ITEM 4.1 (c)

Issue/ Objection:
Car Parking

**85 Harrington Street
The Rocks
GOLDEN AGE & HANNAS THE ROCKS**

TITLE
**RESPONSE TO DoPE
ITEM 4.1 (c)**

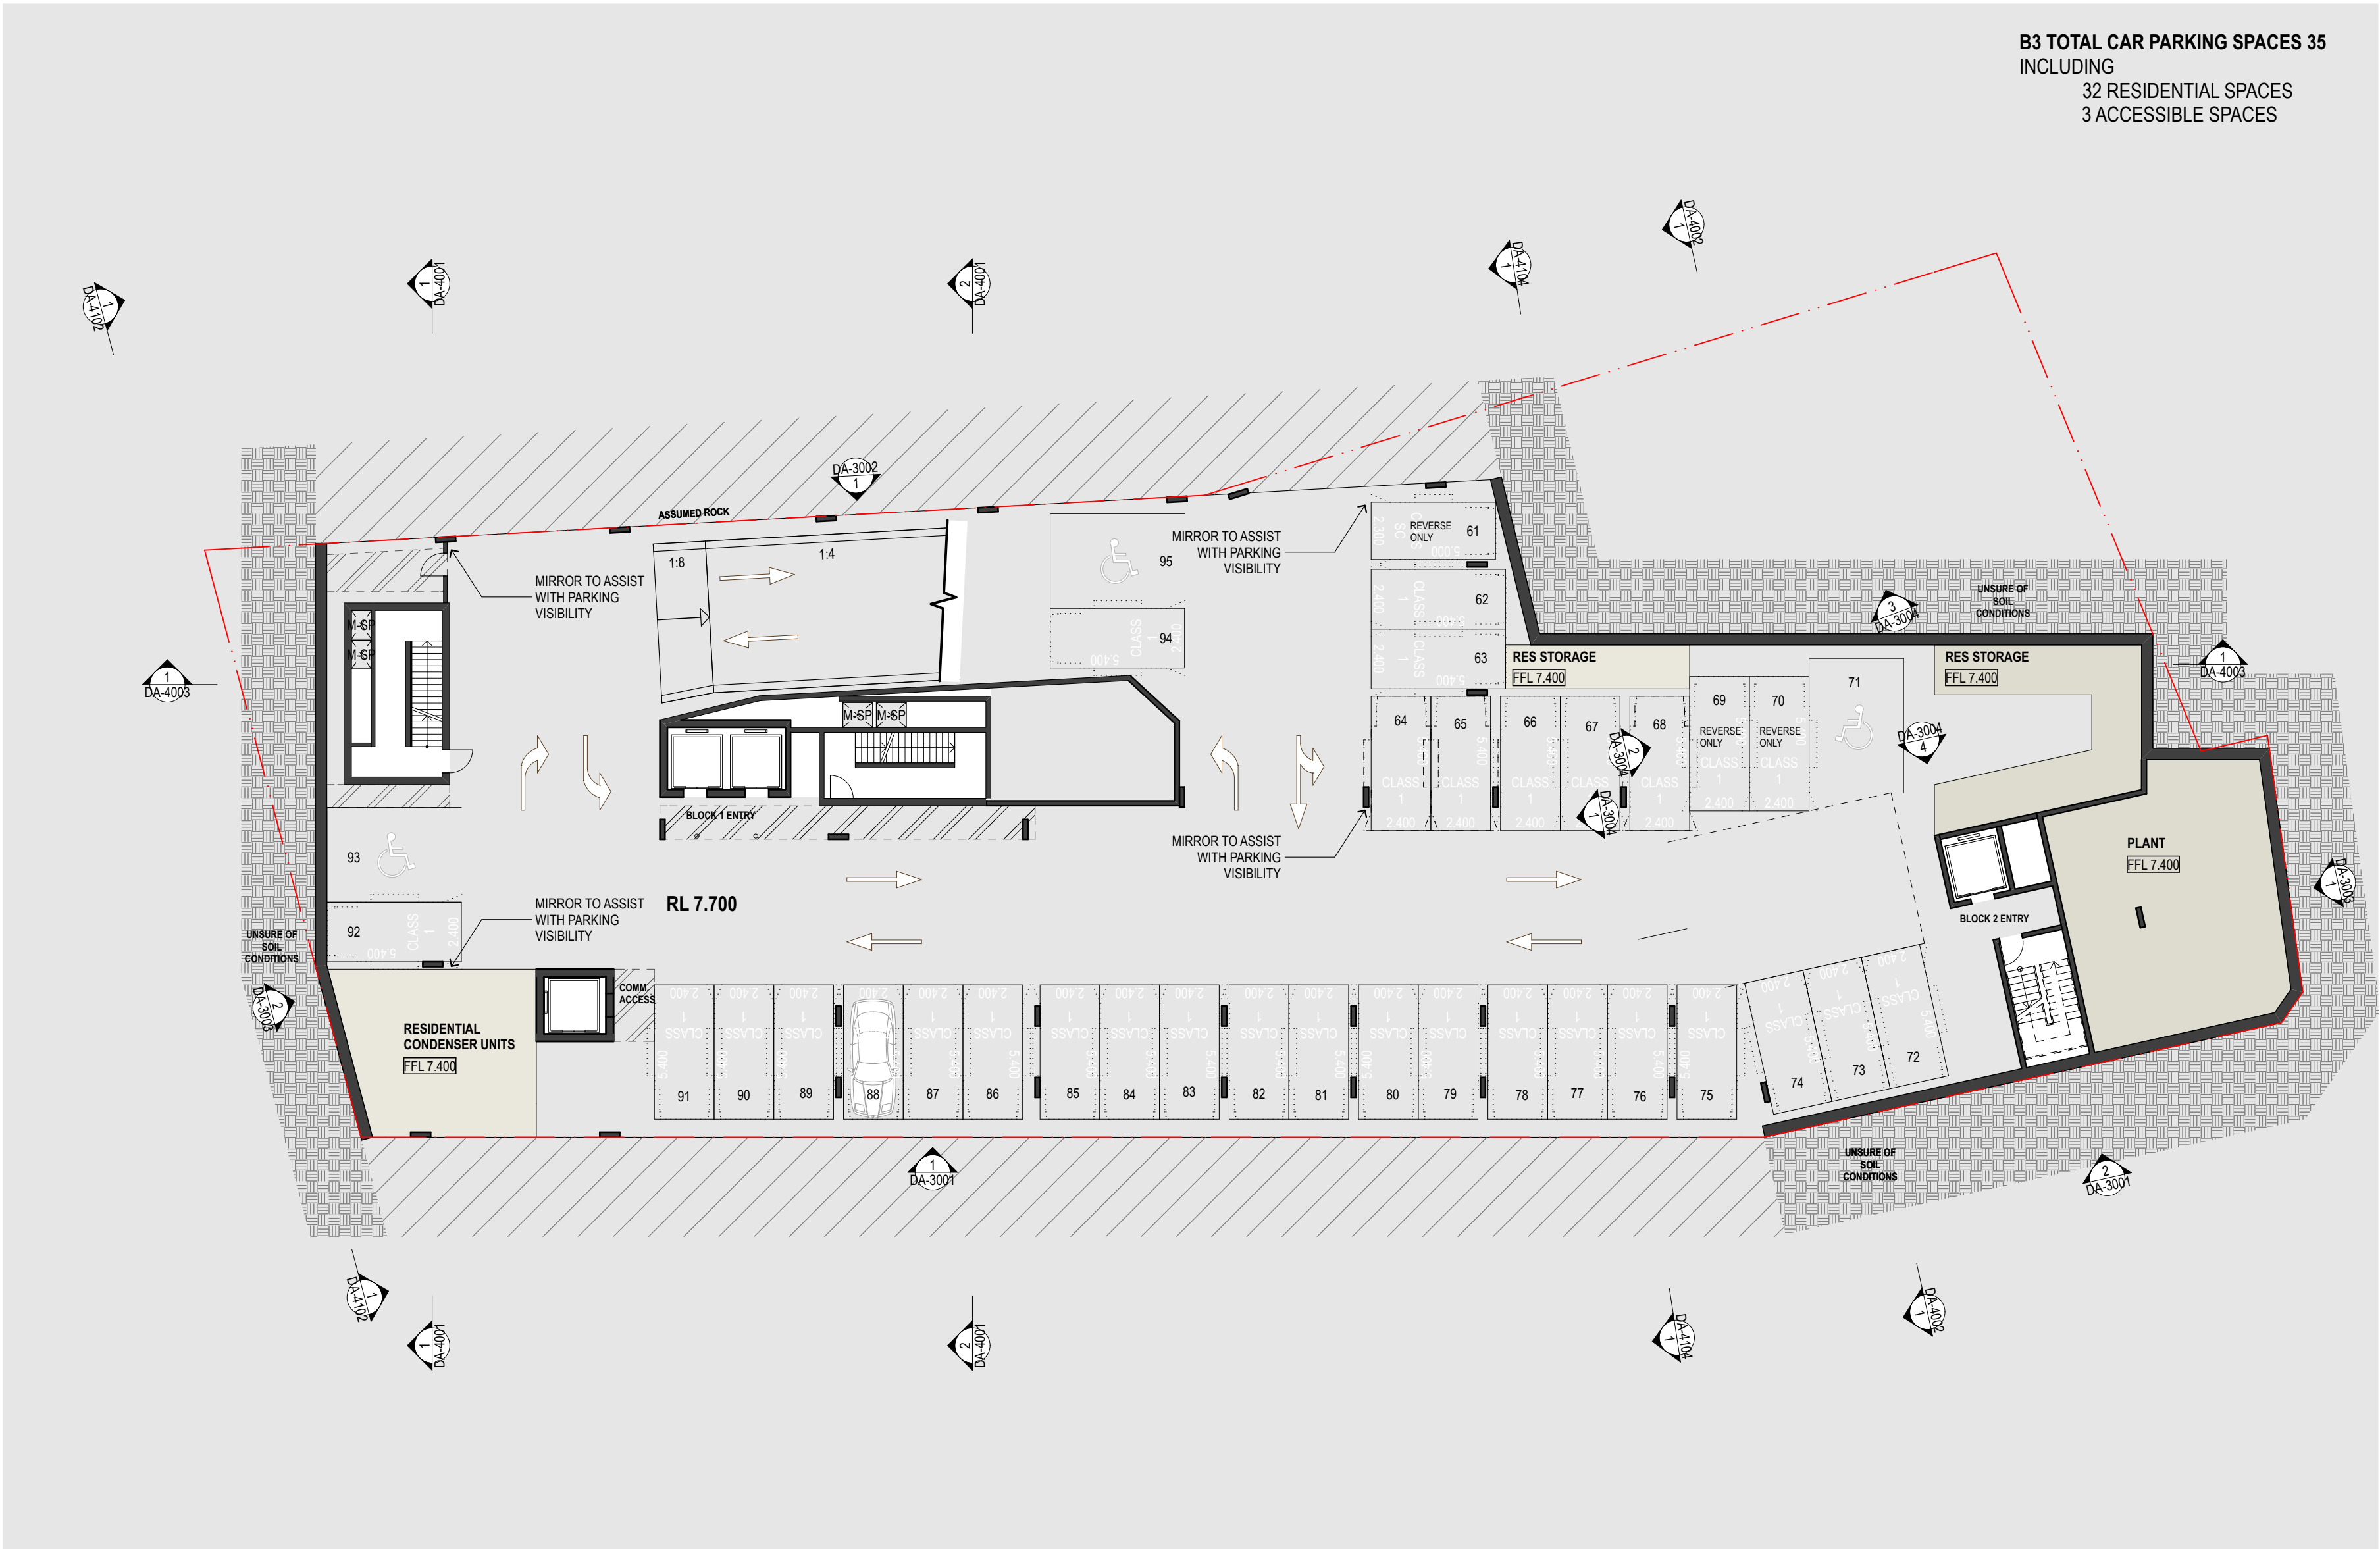
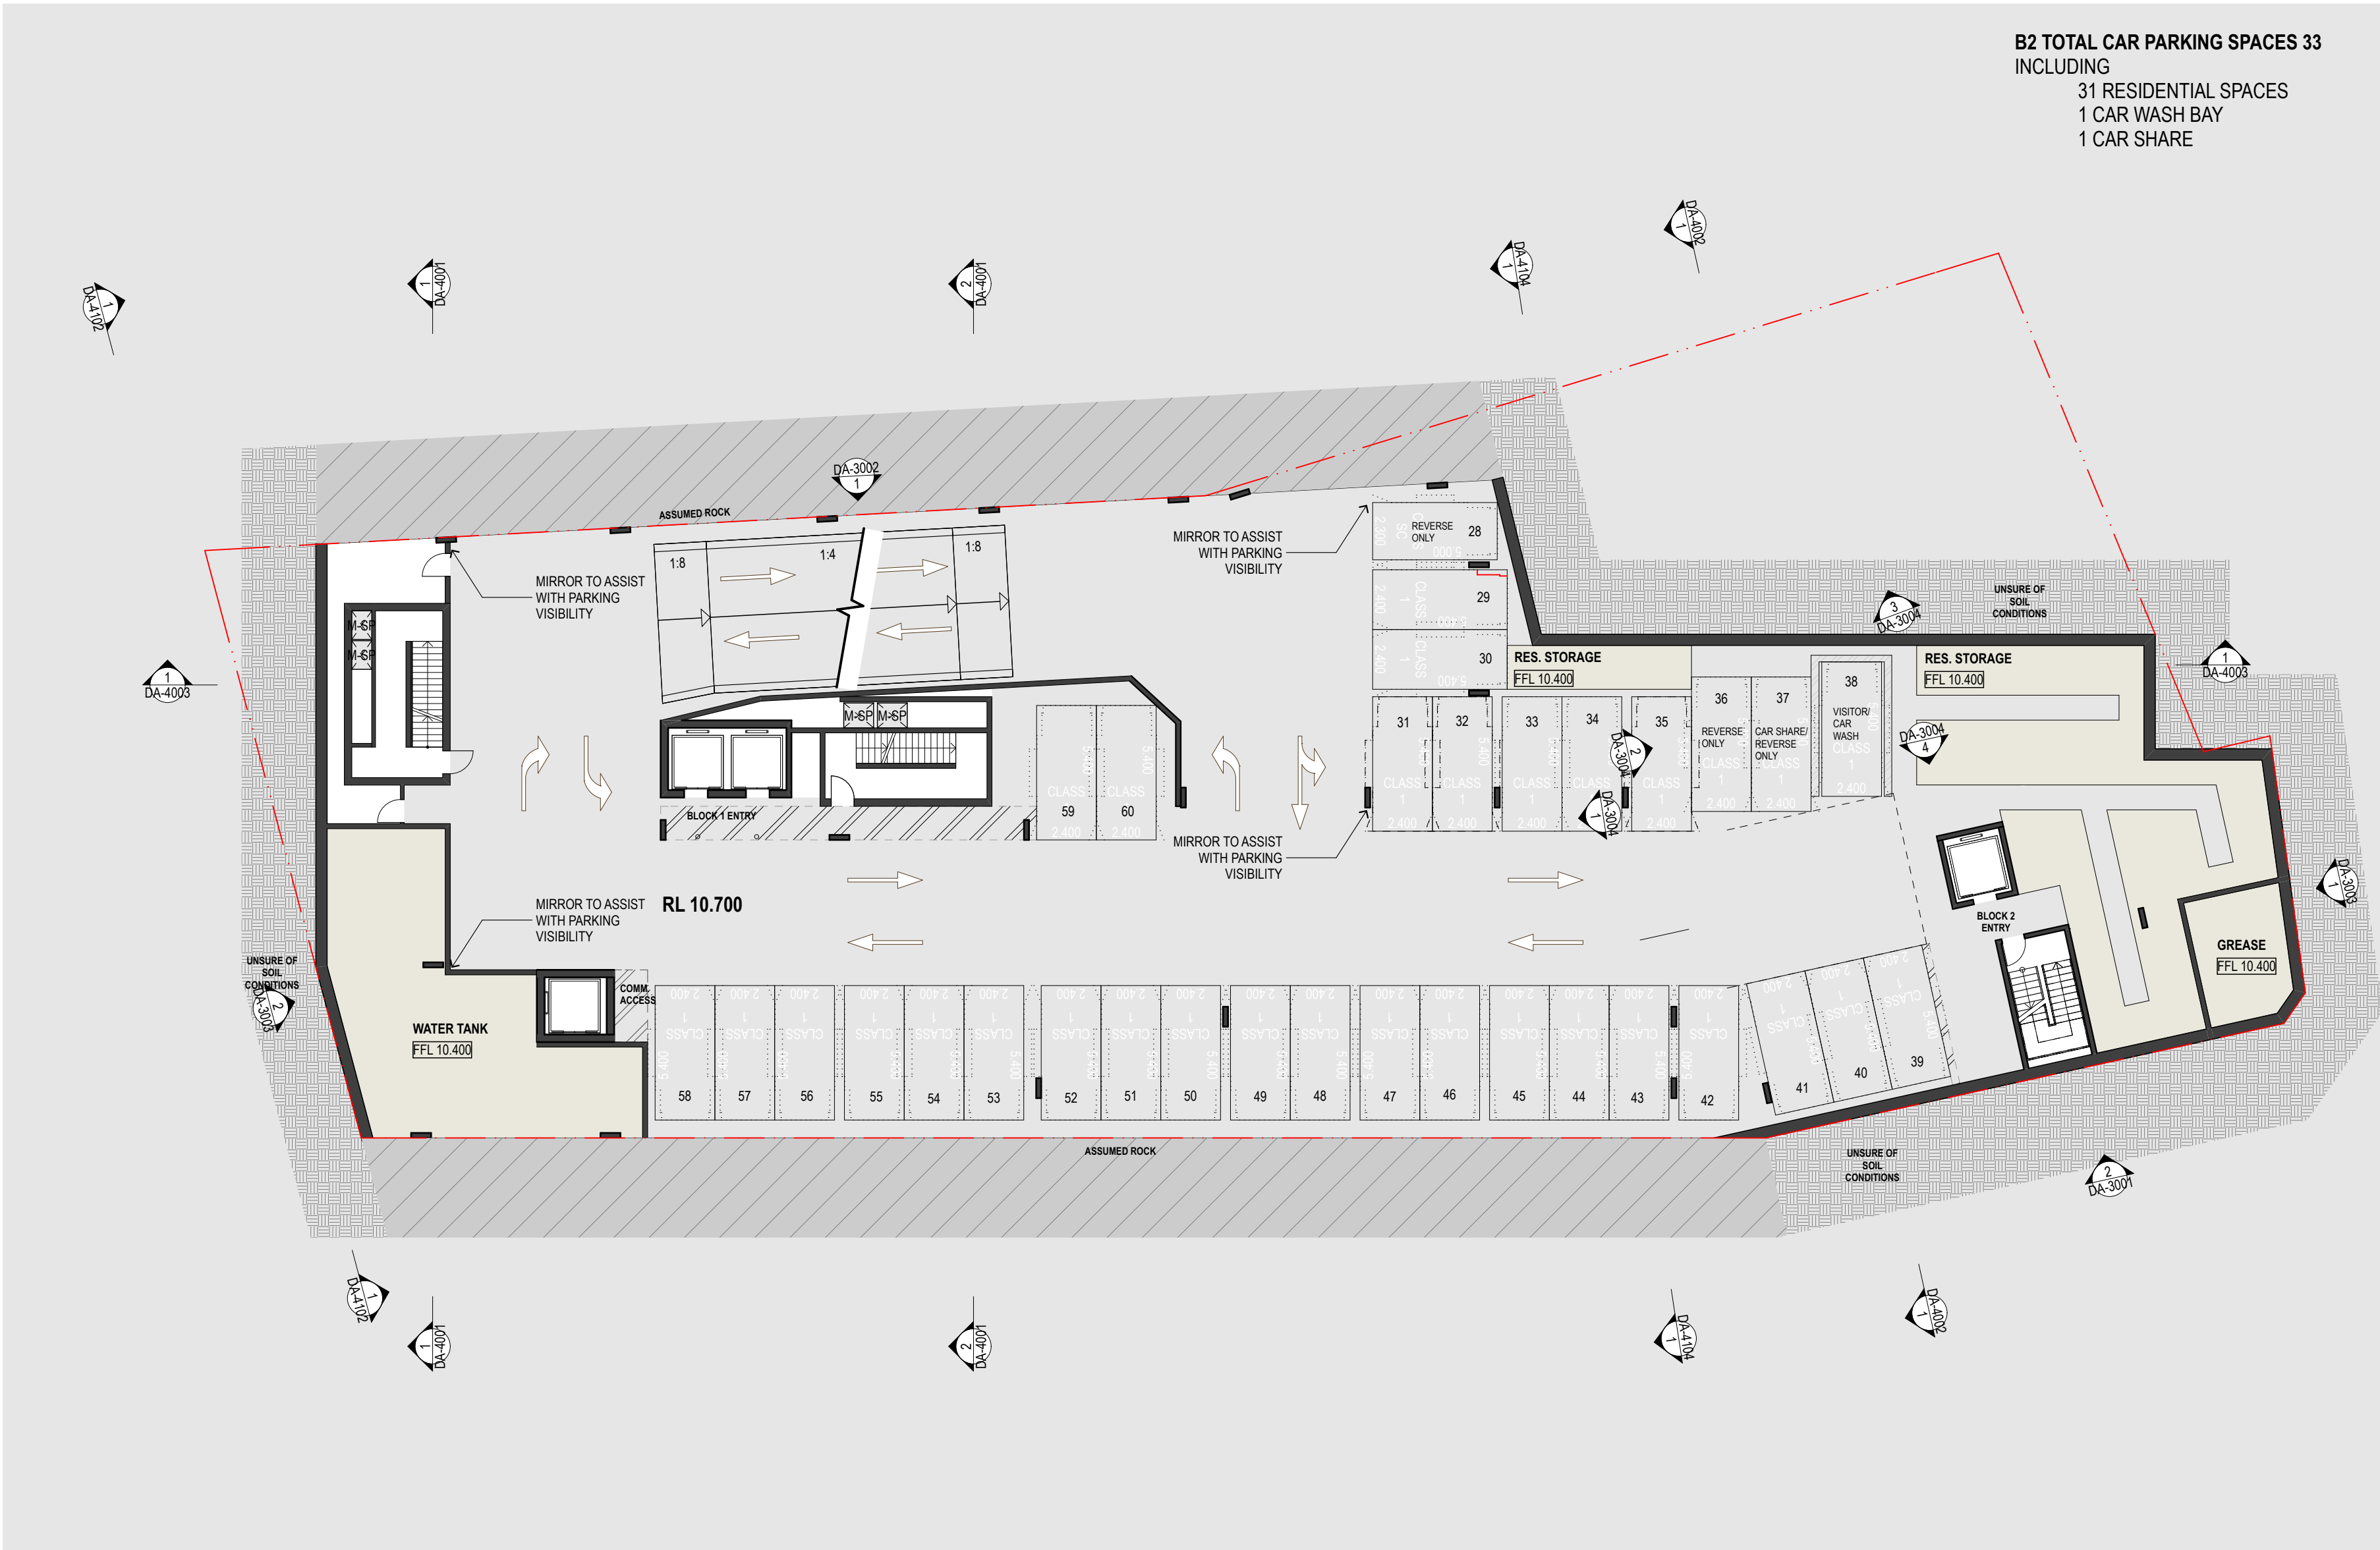
Description:
Given the location of the site within the CBD and close proximity to a variety of public transport nodes, consideration should be given to further rationalisation of the proposed number of residential car parking spaces.

Response
Refer to drawings and report provided by the traffic consultant.

The internal configuration of the basement car park and loading areas have been designed in accordance with the both AS2890.1, AS2890.2 and AS2890.6.

In our TIA dated August 2017 comments were made in relation to limited queuing area which was commentary in relation to a superseded design for the development. It is noteworthy that the proposed development provides a two way ramp which ensures that queuing will not occur on-street. Swept path analysis confirming passing opportunity of a B99 & B85 design vehicle is provided in **Attachment 2** for reference.

The basement design has been amended so that the proposed development now provides a total of 114 bicycle parking spaces in accordance with the requirements set out in the City of Sydney's LEP 2012 and as detailed in **Table 4** overleaf. The bicycle parking spaces have been indicated on the amended plans which are included in **Attachment 3** for reference. Please note that commentary on the End of Trip Facilities will be provided by the architect.
